DRAINAGE REPORT

PCD File No. PPR2325

**Town of Ramah Wastewater
System Improvements**

DATE: March 26, 2024

GENERAL LOCATION

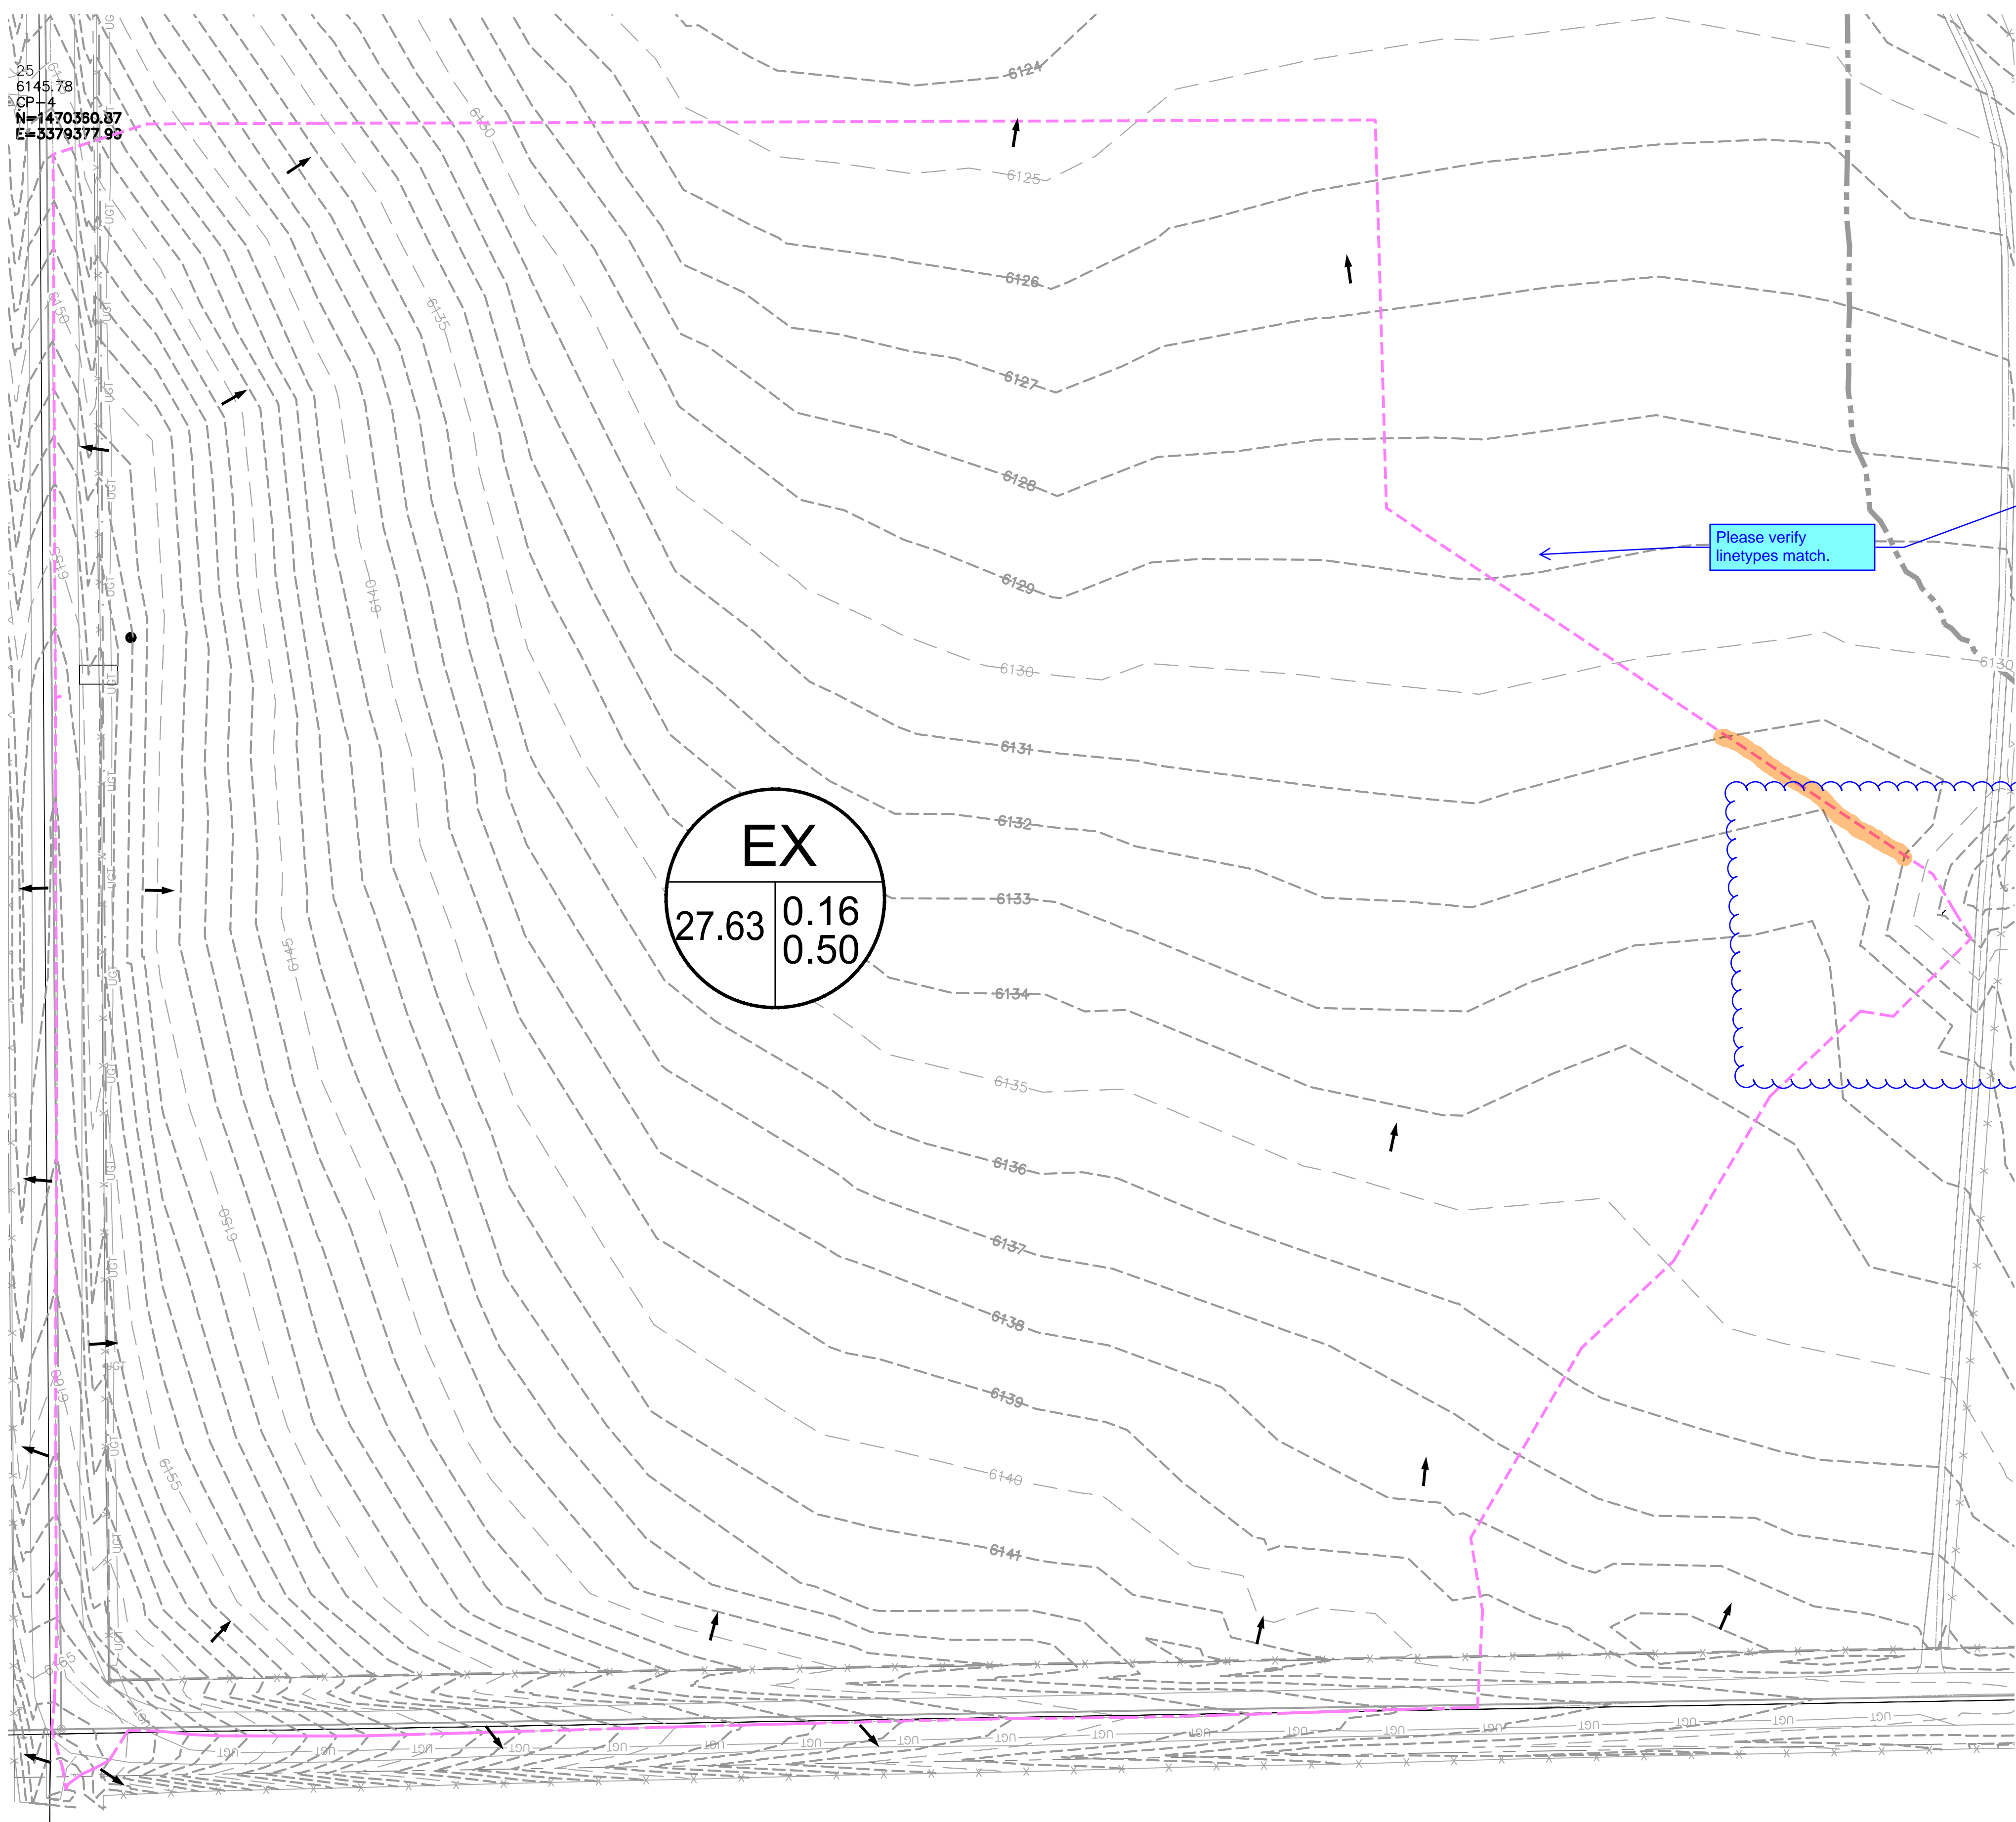
OS-1? changed to match with report terminology OS-2?

Drainage map shows a Basin A-3. Please include in calculations or re

Included A-3 in discussion.
